**Our Ref: AL/31/13/
Your Ref:**

Application for Planning Permission for Works or Extension to a Dwelling

Development Proposed conservatory to front elevation & detached double garage
Location Redtile Cottage Brittens Lane Aldingbourne

G.F. PLAN (1:100)

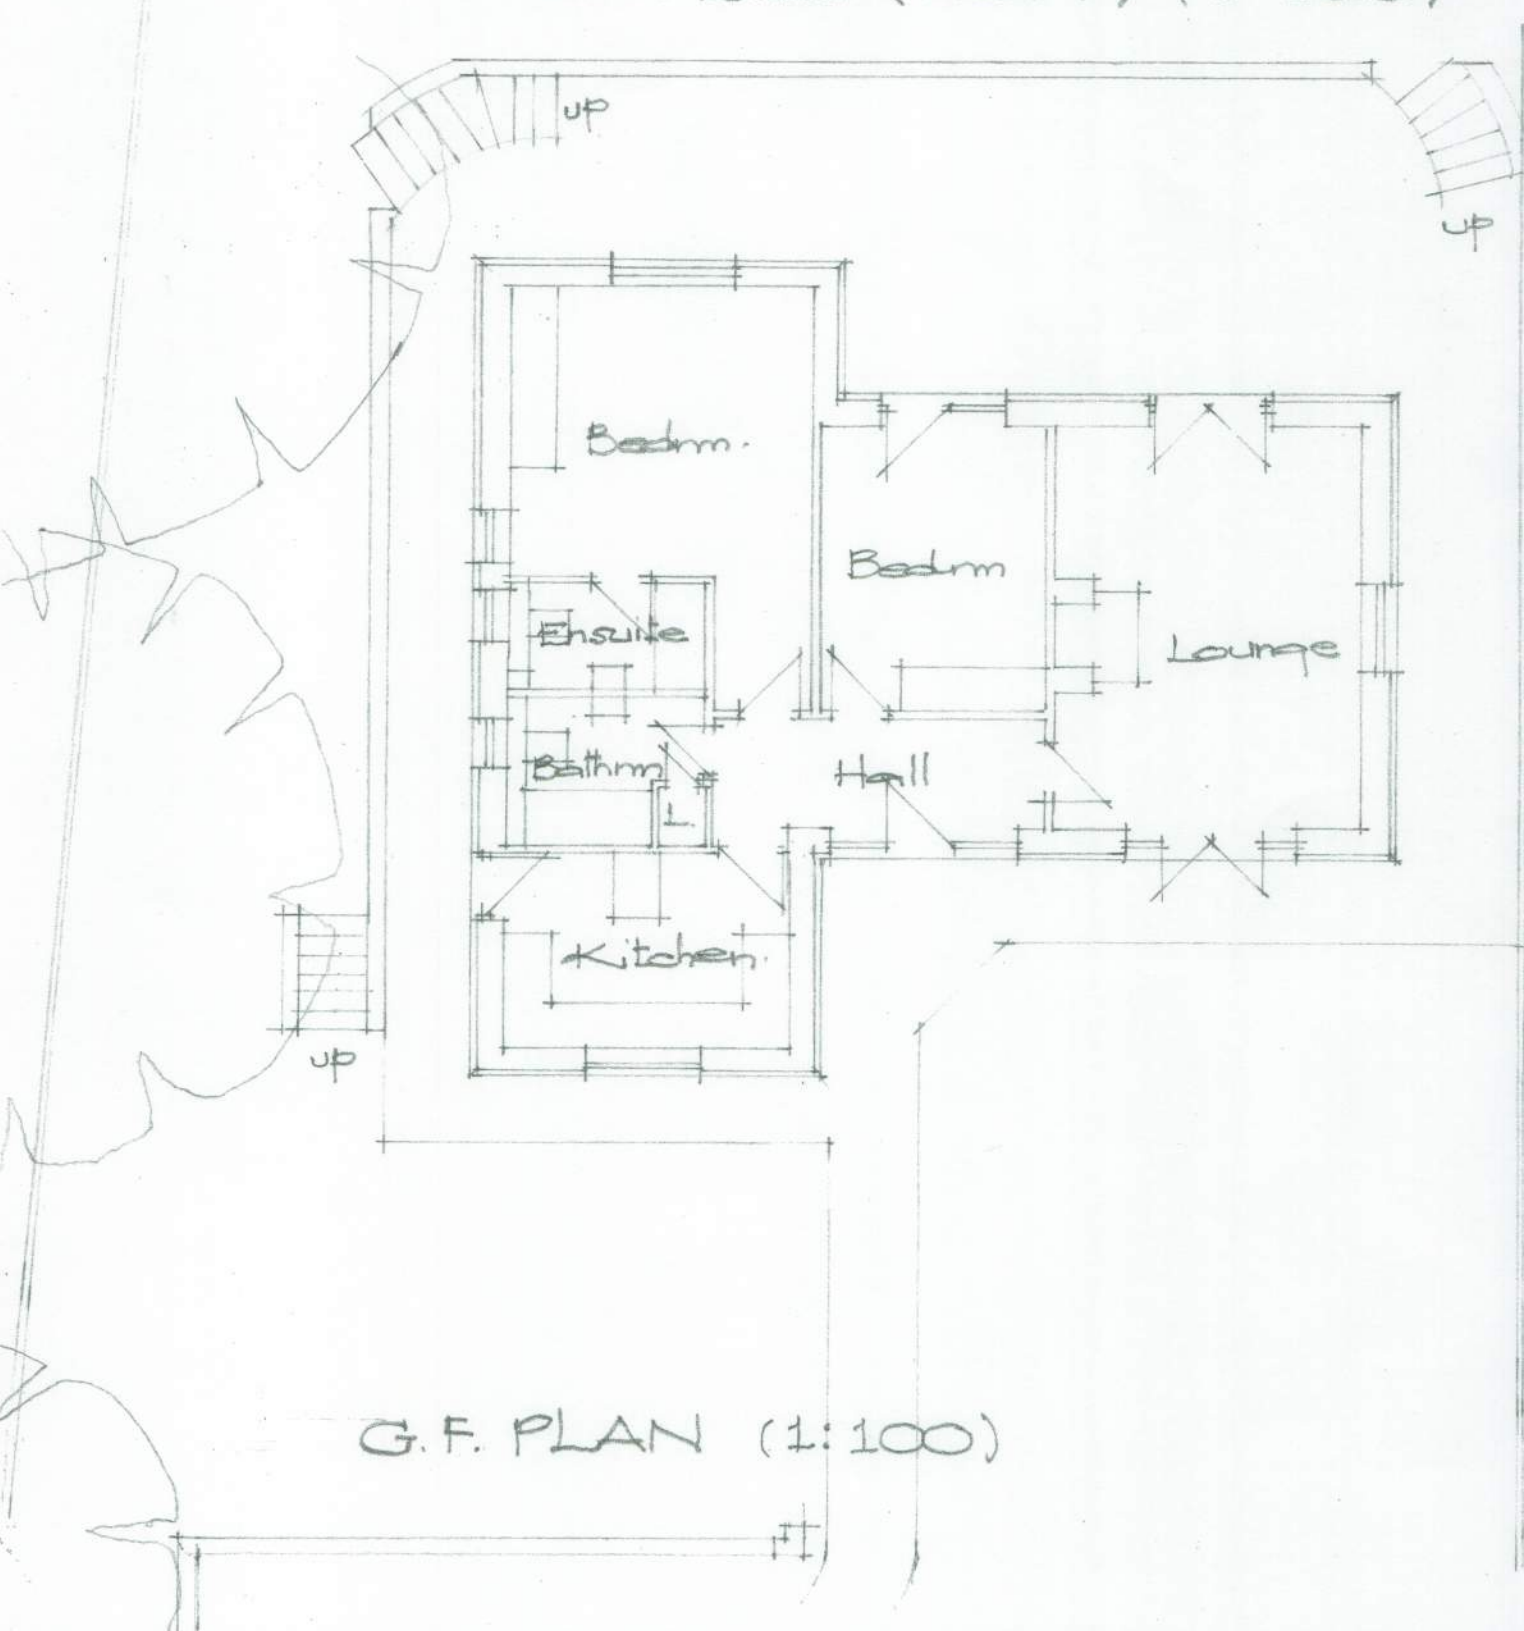
Please submit 1 electronic or 3 paper copies of revised proposed floor plans with all windows and doors shown in the same way at a scale of 1:50 in accordance with the guidance notes available on our website detailed below (click on National List).

REAR GARAGE ELE. (EAST) (1:100) BLOCK PLAN (1:500)

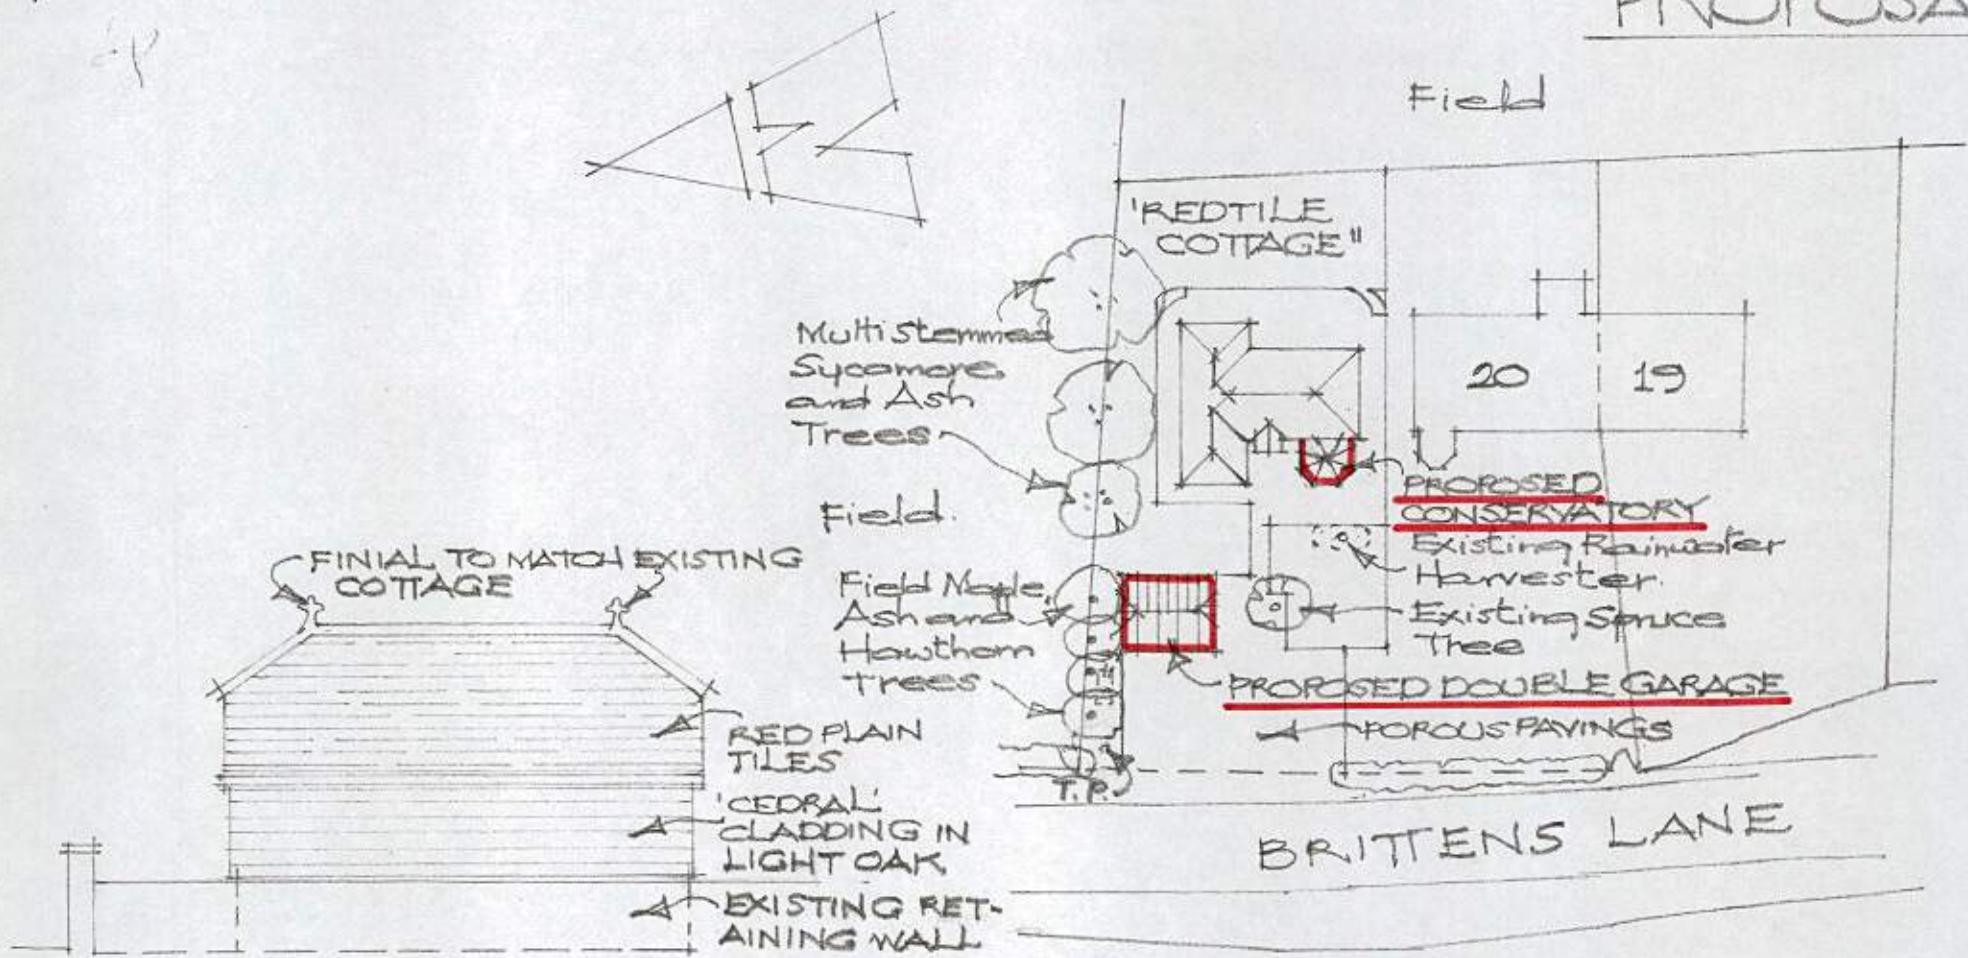
Please submit 1 electronic or 3 paper copies of a revised block/site plan with the proposed works clearly highlighted in another colour in accordance with the guidance notes available on our website detailed below (click on National List).
